From: Chris Moore 
Sent: 25 April 2019 08:29
To: Amber Willard
Cc: 'roy penny'
Subject: AW/79/19/HH - 24 ABeckets Avenue, Aldwick, Bognor Regis.

I write on the above application currently under consideration.

PROPOSED ROOF PLAN

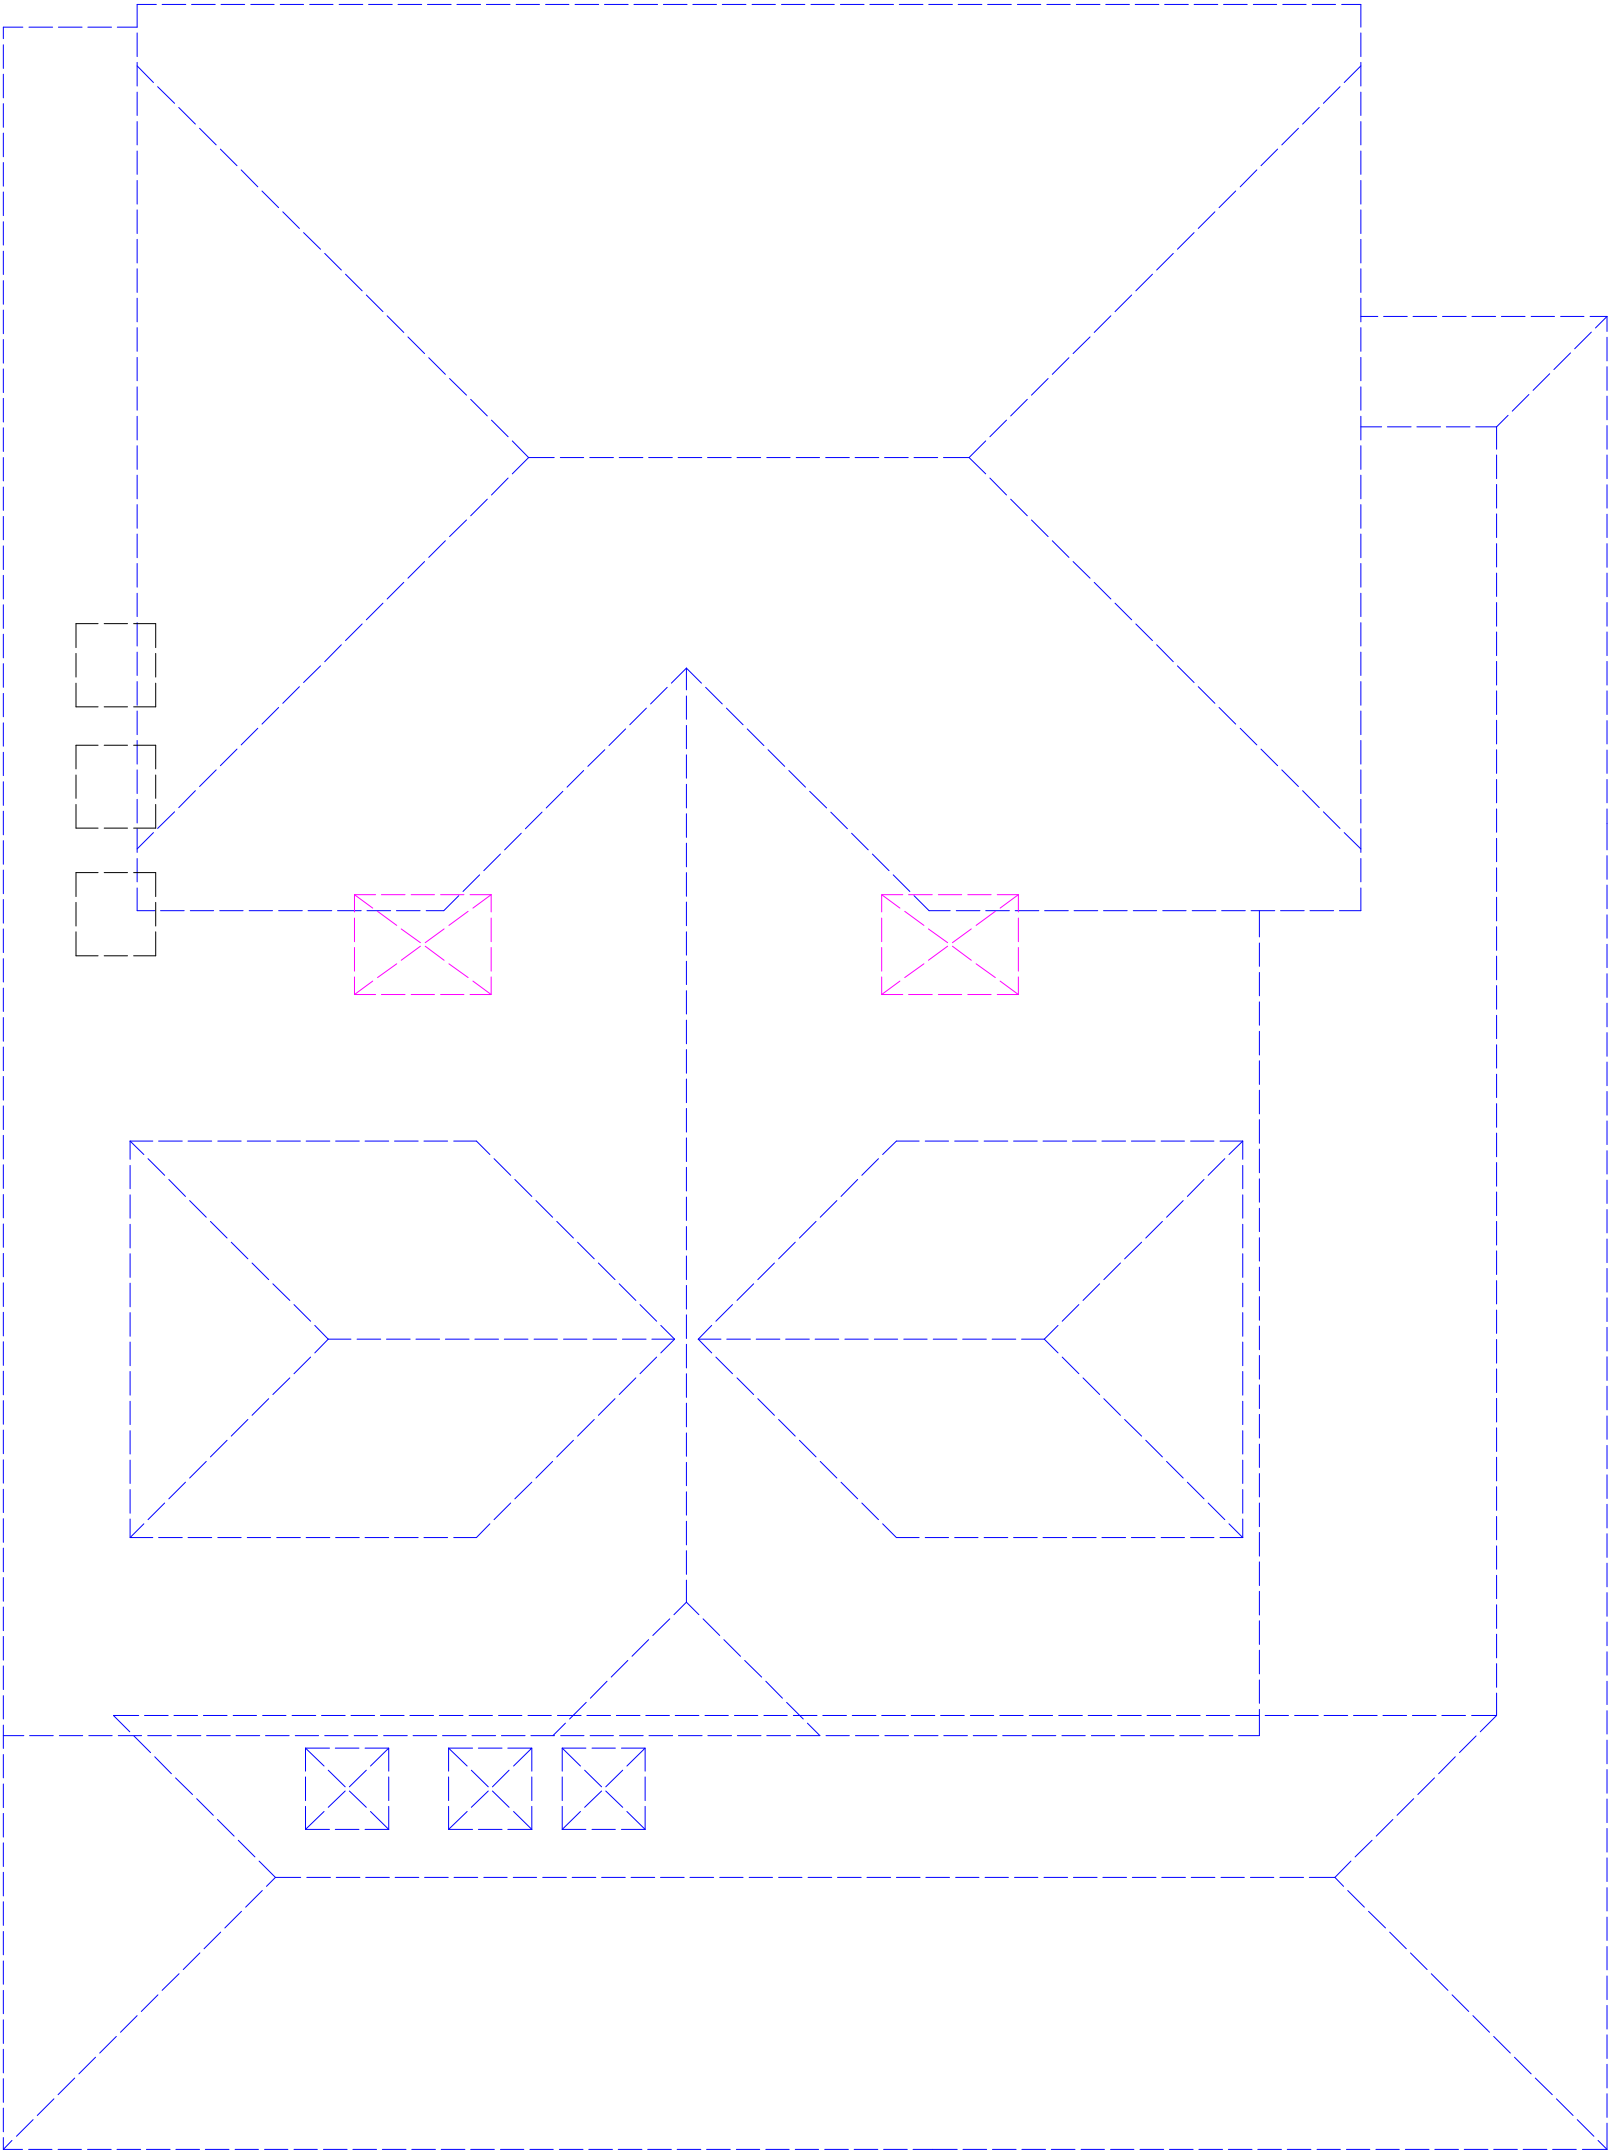
I notice that the drainage engineers have asked for a full investigation of the surface water drainage provision for the development because there is a watercourse to the rear of the site.

It should be noted that the proposed surface water drainage for the additional 11 m2 in roof area added will be taken to a new soakaway (1.0 m3 capacity below the invert level of the entry pipe) to the front of the property.

This is located a significant distance away from the 'watercourse' and as such with the minimal increase in area should be deemed acceptable. I would be grateful if these comments could be included in with the application.
